STATE OF NORTH CAROLINA
DEPARTMENT OF TRANSPORTATION

July 24, 2020

Subject: **Modification Request for Section 404 Individual Permit, Section 401 Water Quality Certification and Neuse Riparian Buffer Authorization** for Interstate 40 Widening and Improvements from I-440/US 64 (Exit 301) to just north of SR 1525 (Cornwallis Road), including improvements to NC 42 and SR 1010 (Cleveland Road) in Wake and Johnston Counties, Federal Aid Project No. IMNHF-040-4(139)301; TIP Numbers I-5111 and I-4739, Division 5. Debit \$570 from WBS Element 42346.3.1.

PERMIT DRAWING  
SHEET 92 OF 125

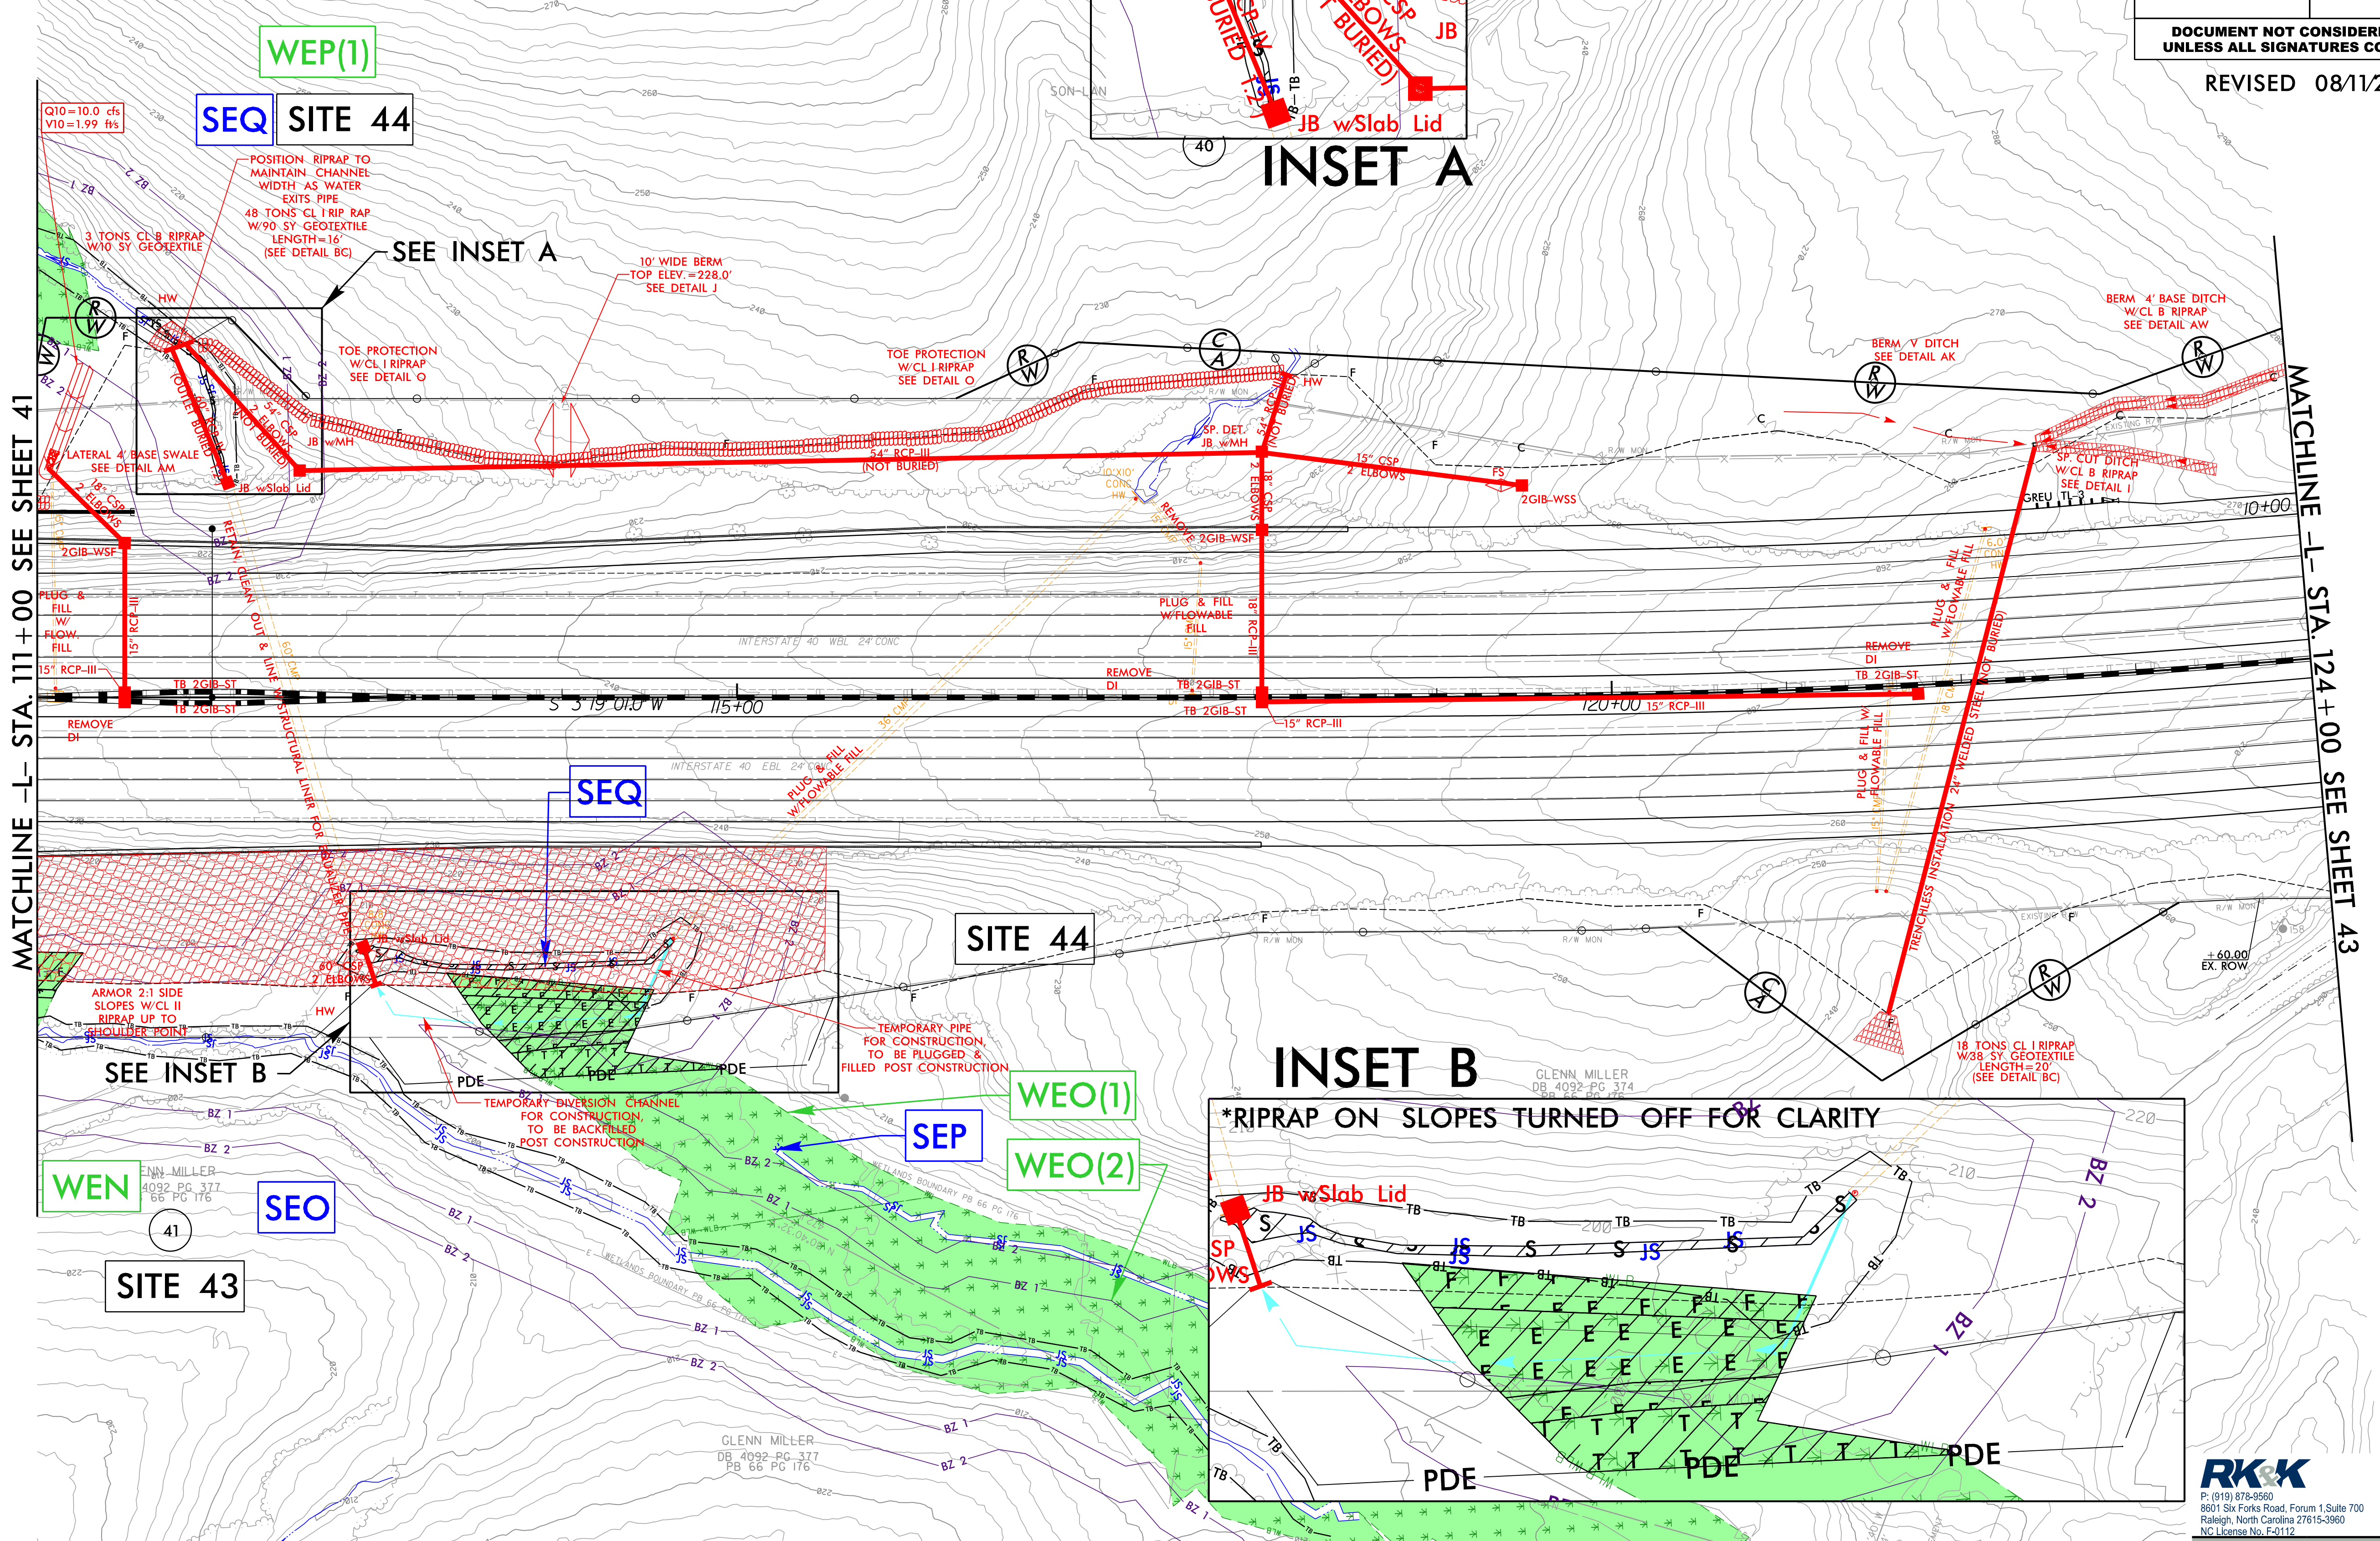
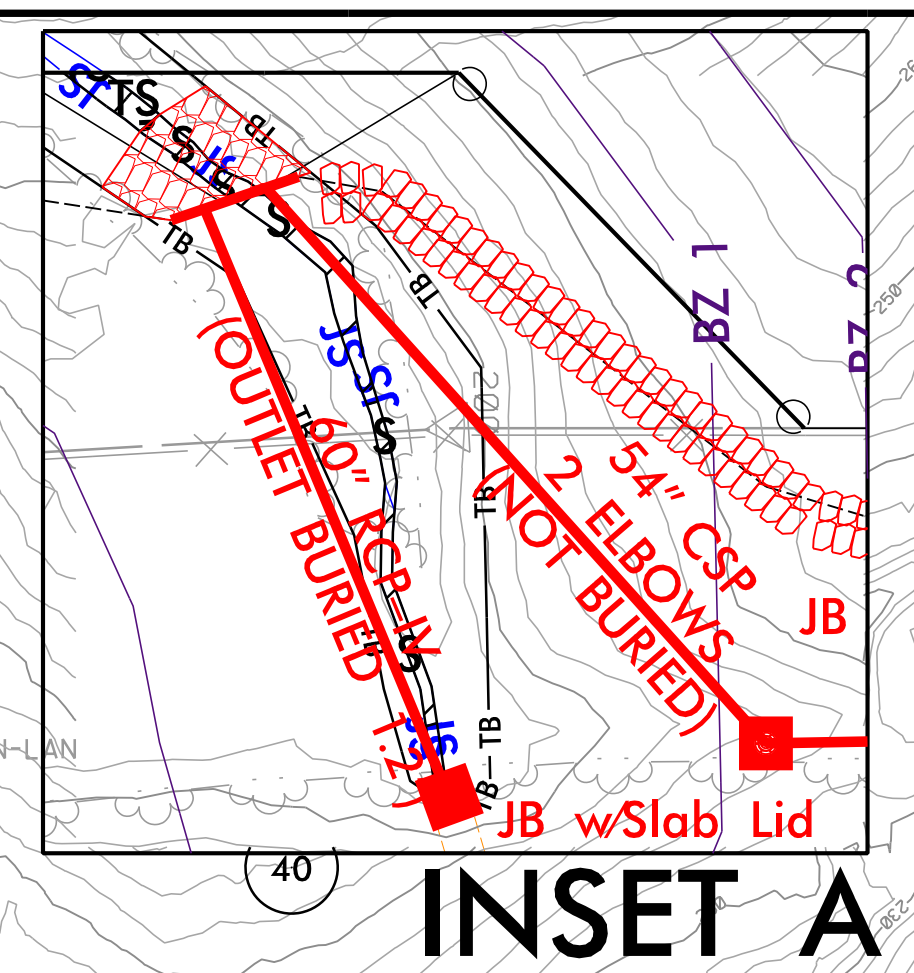
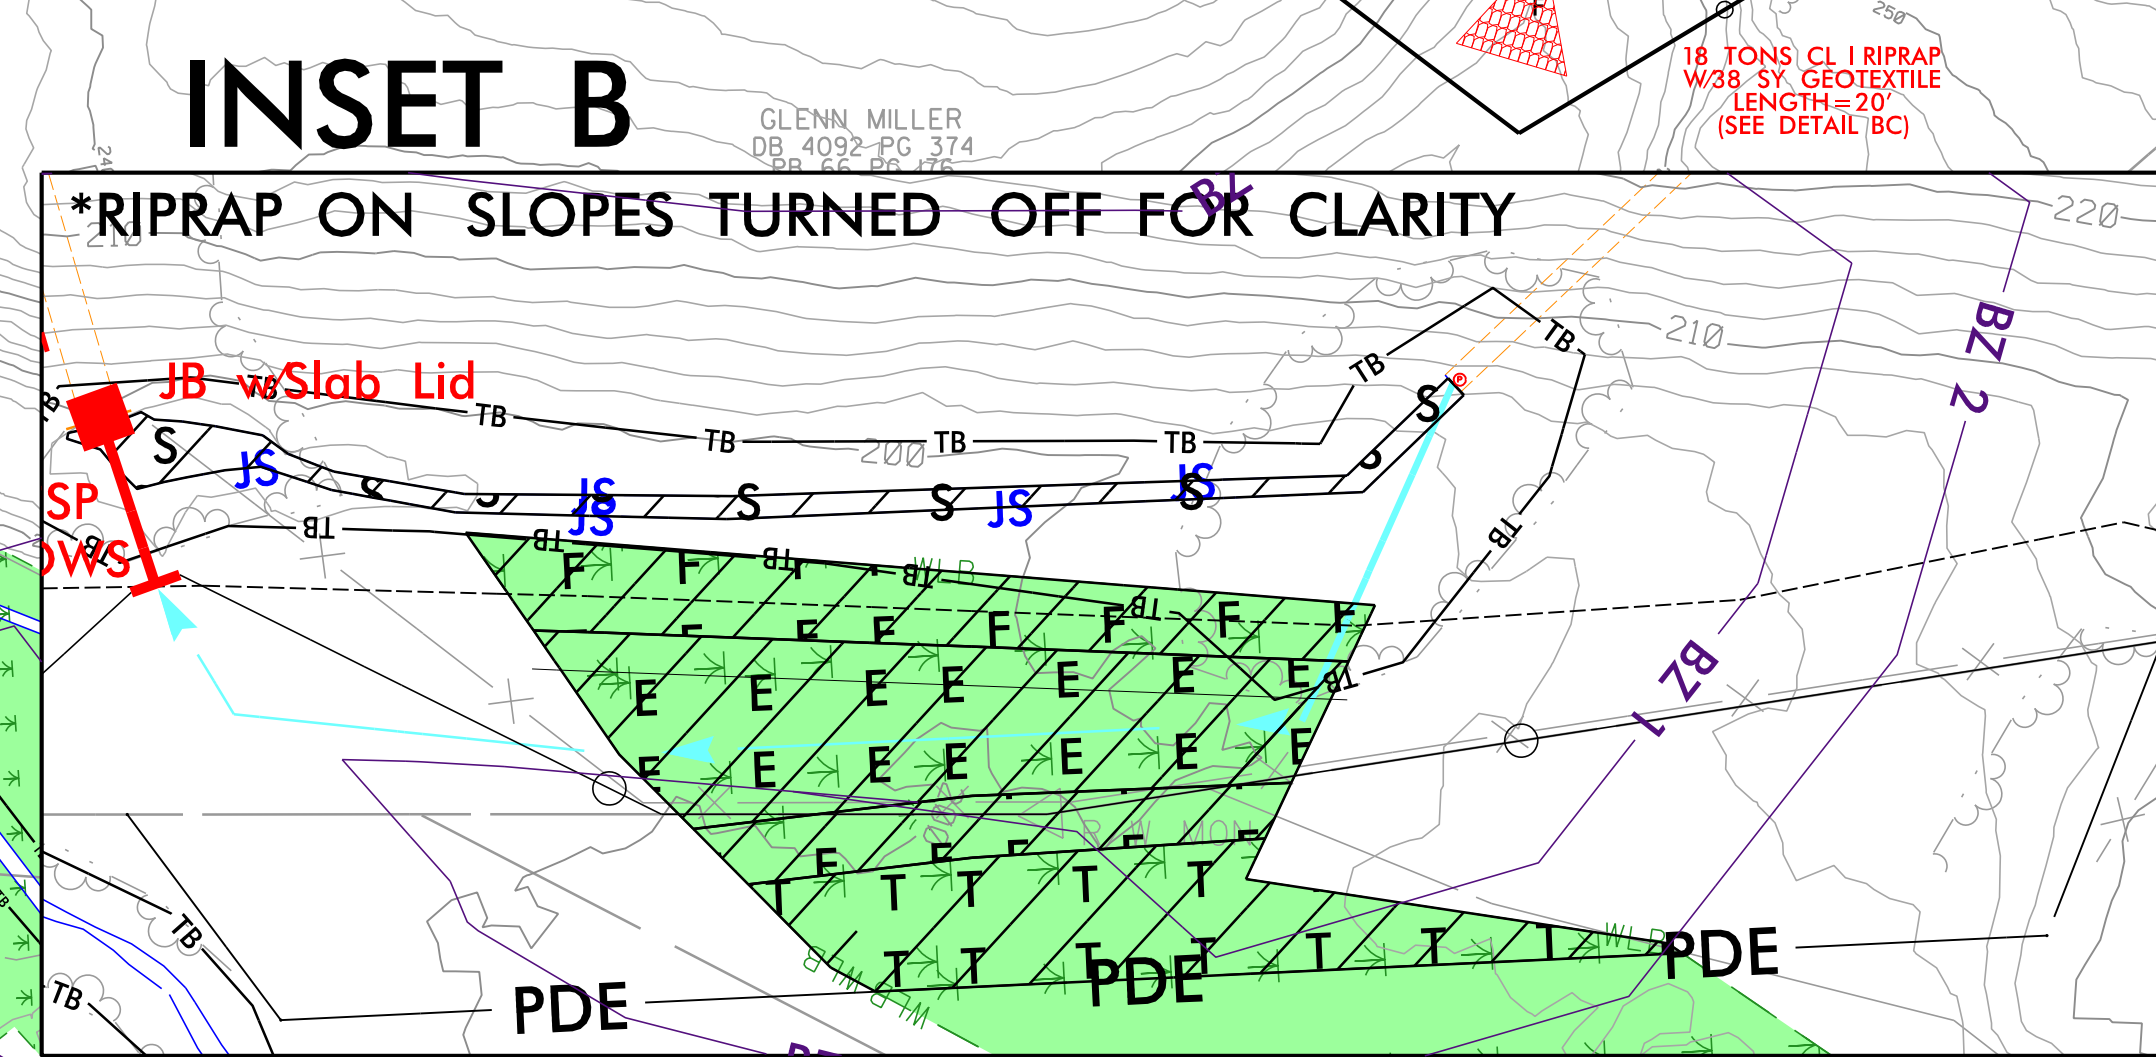
A field revision is being requested at Site 44. Currently, stream SEQ is piped from the east side of I-40 to the west side, travels along the west side of I-40 for approximately 80 feet, then is piped back to the east side. The original design kept the drainage pattern by boring a new 54" steel pipe to the west side of I-40 and then extending the existing 60" pipe to convey SEQ back to the east side. The new design proposes to install a pipe along the east side of I-40 that outlets to the same 60" pipe, thus eliminating the need to bore a new 54" steel pipe. The 60" pipe will still be extended to convey any drainage from the west side to the east as well as to act as an equalization pipe.

- Permit Drawing 91: plansheet 42 without contours
- Permit Drawing 92: plansheet 42 with contours
- Permit Drawing 93: plansheet 42 profile
- Permit Drawing 124: impact summary table
- Permit Drawing 125: impact summary table
- Buffer Drawing 42: plansheet 42 without contours
- Buffer Drawing 51: buffer summary table
- Buffer Drawing 52: buffer impact summary table
